Inspector's Report ABP 305895-19.

Whether the refurbishment of four windows at the front, 3 windows at the rear, fitting of draft weather seals and restrictors to windows, and whether re-landscaping of front garden is, or is not development and is or is not exempted development.

5 Dartmouth Square, Dublin 6.
(Protected Structure)

Partial Site Plan, Front Garden - PROPOSED

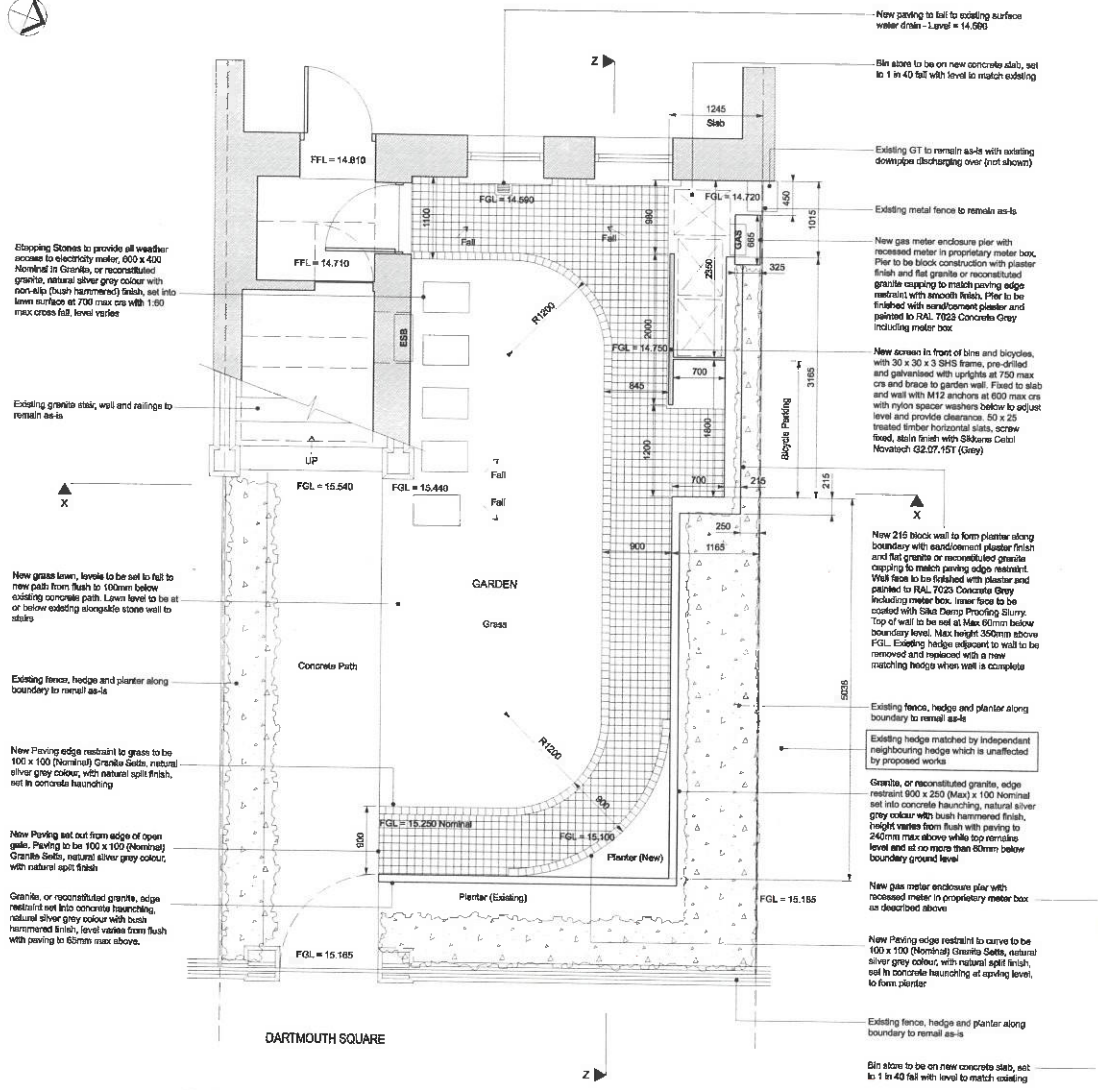
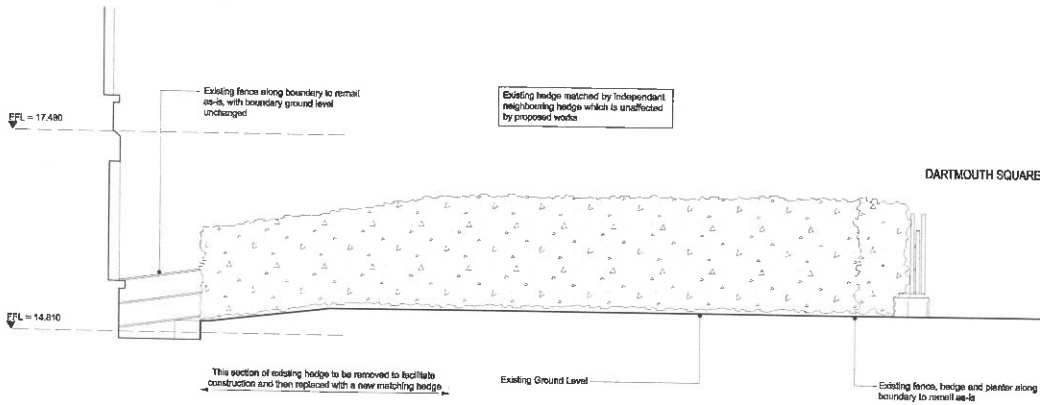
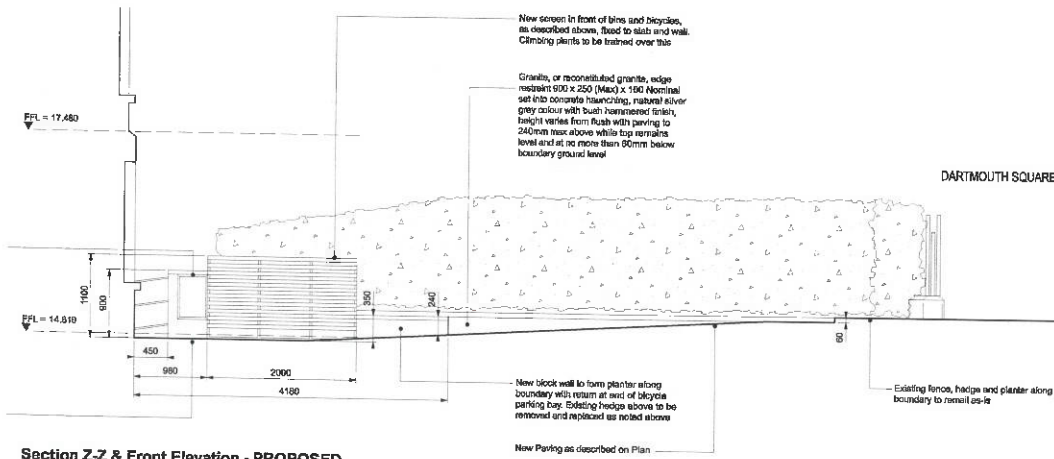
- The proposed level drop of 500 mm for the front garden, installation of setts and stepping-stones and raised planter heights with loss of existing landscaping are substantial and the substantial level changes to the front garden which will be at a different level to neighbouring gardens and, this along with the introduction of extensive hard landscaping will result in a major departure from the historic design.

- 4.5. The proposed works to the front garden subject of the Question, constitute significant alterations to which alter the setting and composition of the protected structure. The interventions to provide for a fall of circa 500 mm to the finished ground level to the front garden space to the front of the house, adjacent to and just forward of the granite staircase are considerable,

- 4.6. These alterations would alter the historic design characteristics for historic townhouse front curtilages. The proposed hard landscaping around the perimeter inside the front railings along the side with the fall toward the front of the house, the planters, timber screen and new walling providing housing for bin and cycle storage individually and cumulatively obliterate typical historic characteristics established by the geometry and proportions of the original front curtilage layout providing the context for the house comprising lawn, some planting and a narrow straight footpath between the pedestrian gate and granite staircase to the entrance. These proposed alterations and interventions within the front curtilage are also incompatible with the context and layouts for the neighbouring property at No 6, given the historic uniformity in plot configuration and layout, features and landscaping for the terraces of houses overlooking Dartmouth Square. The proposed works would affect the setting and character of the protected structure and the neighbouring structures.

- While it is noted the 1100 mm high timber screen and 700 mm high wall, providing for a bin store and cycle storage to be constructed within the front garden are structures which constitute exempt development within Class 3, Schedule 2 Part 1 of the Regulations. These structures are to be erected forward of the front building line of the house they do not constitute exempt development having regard to the conditions and limitations for Class 3 development. However, this consideration is not of relevance if it is established that the works are not exempt having regard to sections 4 (1) (h) and 57(1) of the Act.
